DATE	14/03/2022	JOB	2808	PAGES	1 of 2
PROJECT	SSD-10371 - Trinity Grammar School The Renewal Project SSD				
TO	Peter Brogan				
COMPANY	Bloompark Pact				
FROM	PMDL				
REFERENCE	Architectural Response to Submission for Modification

### 2808 DA102 Site Demolition Plan LO + Above B

01 PLAN
DA132 Level 0 Proposed
Scale 1:200

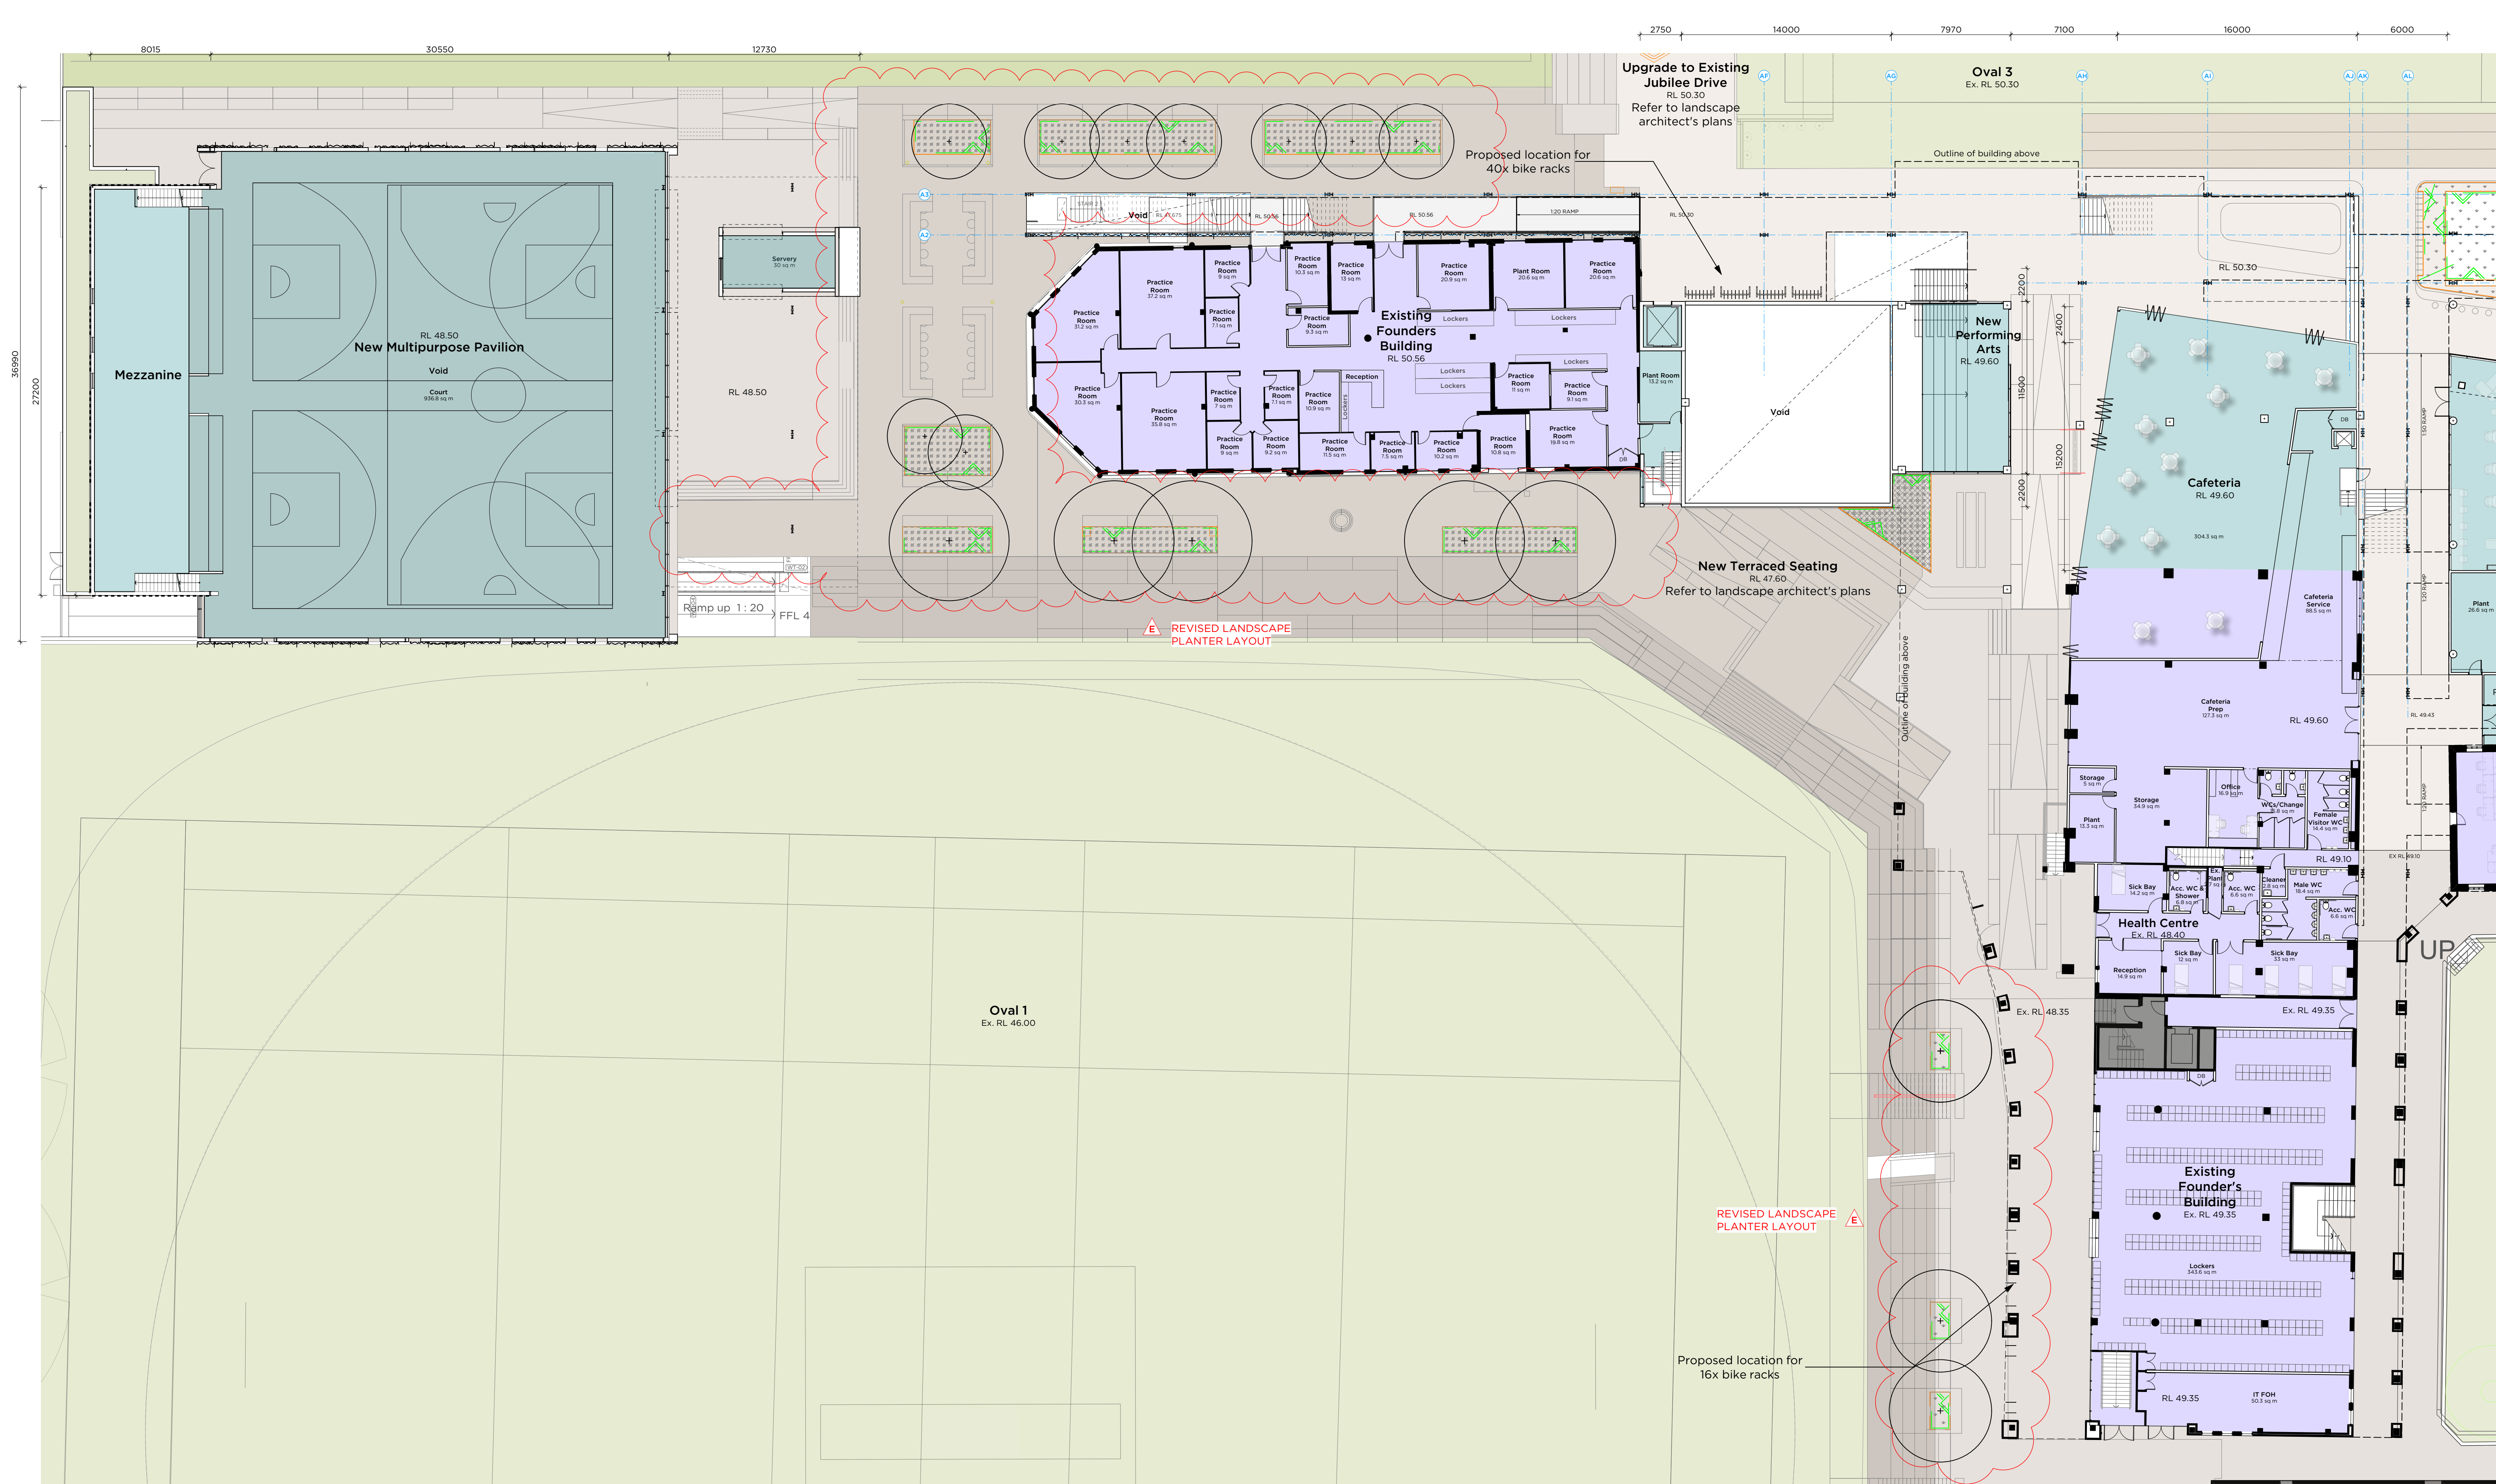
- Landscape Planter design changes following design development and project coordination.
